Department of Primary Industries

OUT16/14058

**Casuarina Town Centre Concept Plan and Project Approval
(MP 06_0258 MOD 10)
Request for Secretary's Environmental Assessment Requirements**

FIGURE No. DA122 (08/09/10)
PROPOSED ADDITIONAL WORKS IN LOT 10

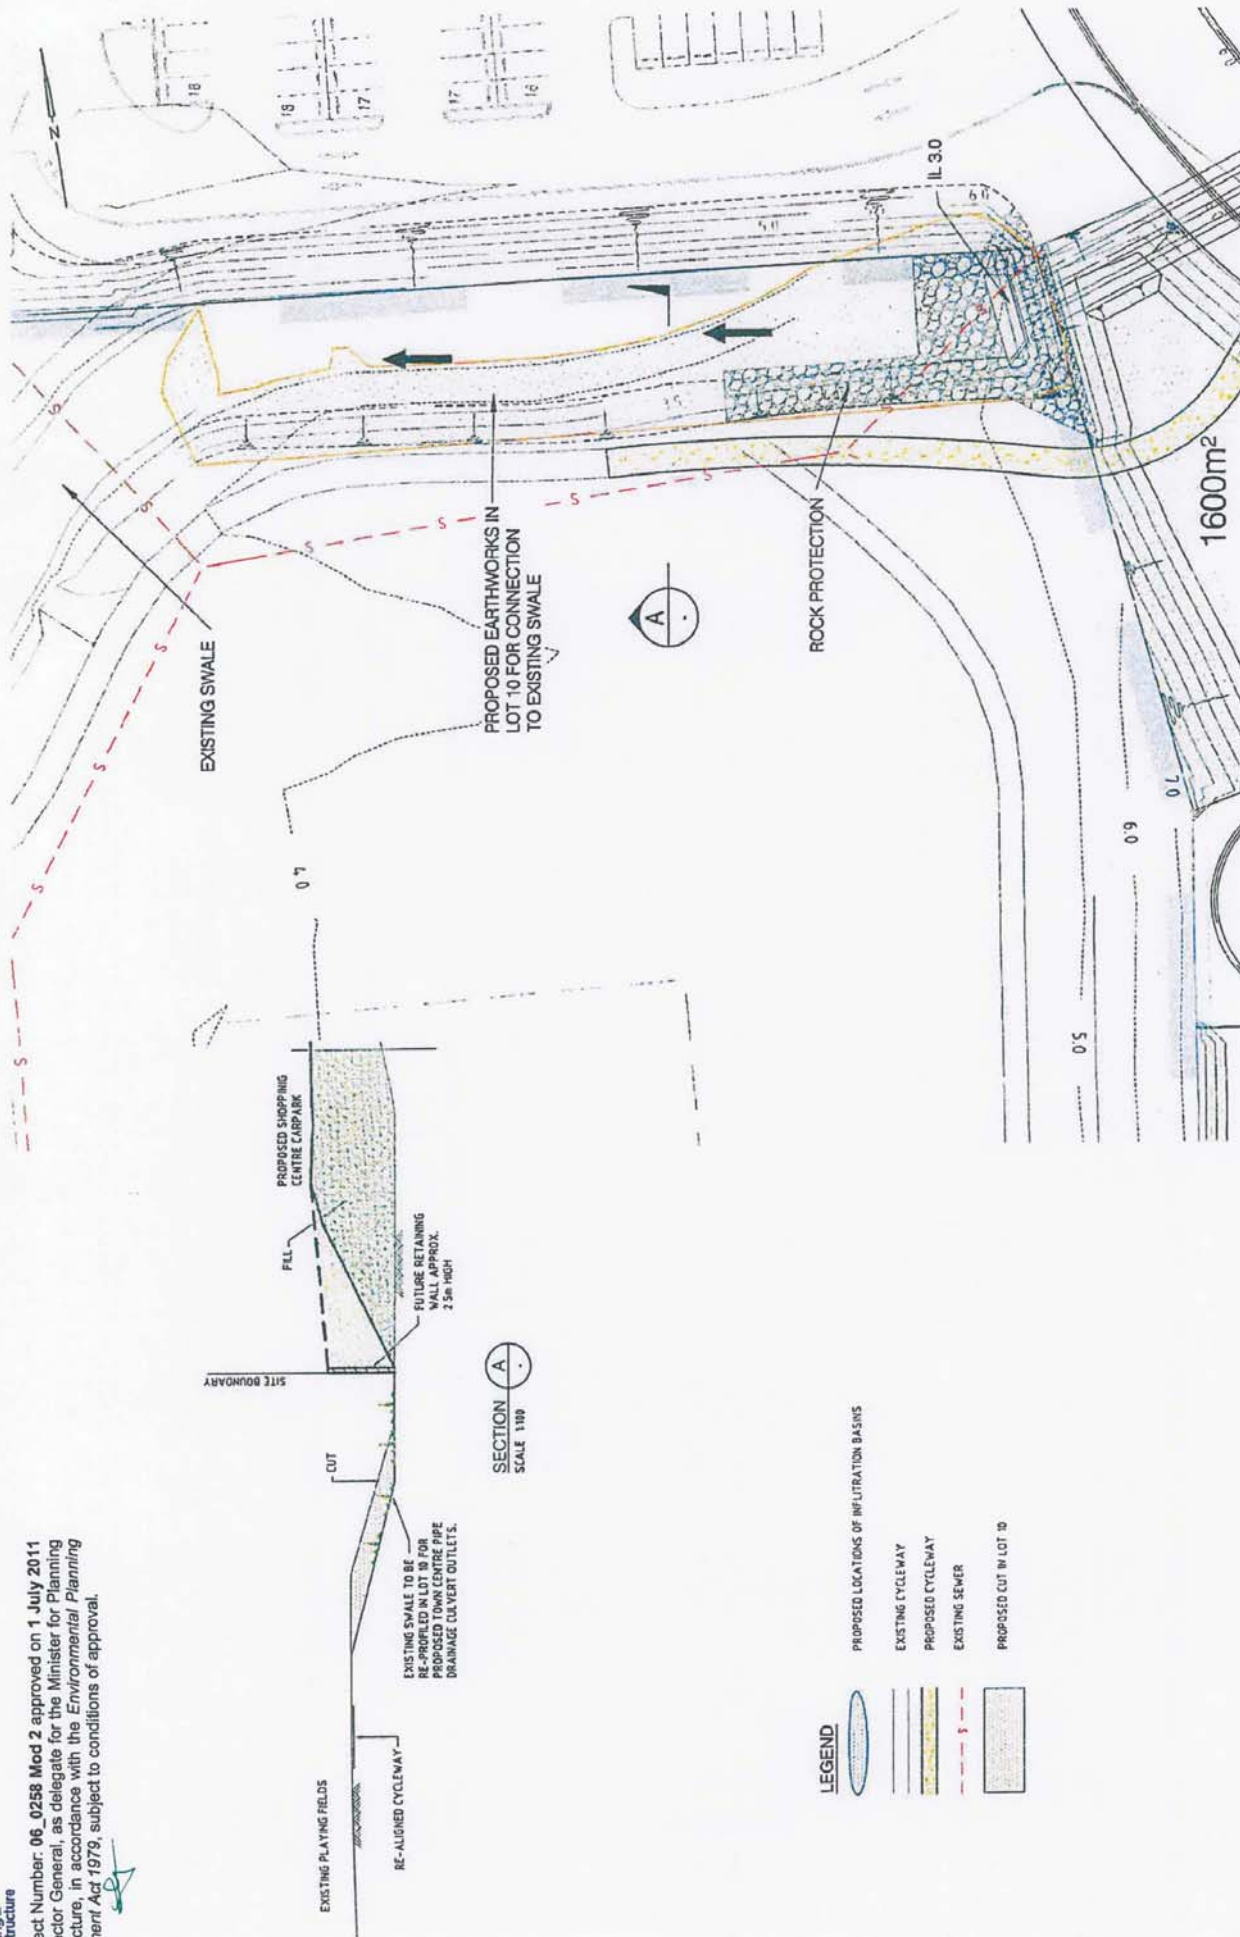
- The modification seeks to replace the existing deep swale that traverses the site with a major stormwater pipe network. Modelling has been undertaken to determine the appropriate size of the proposed drainage system in accordance with Council requirements. Whilst DPI Water is not opposed to the piping of the swale, the report does not outline if groundwater will be intercepted as a result of these works. If there is the potential to intercept groundwater the proponent should contact DPI Water immediately. The proponent may be required to obtain a licence to account for any dewatering of groundwater associated with the works.
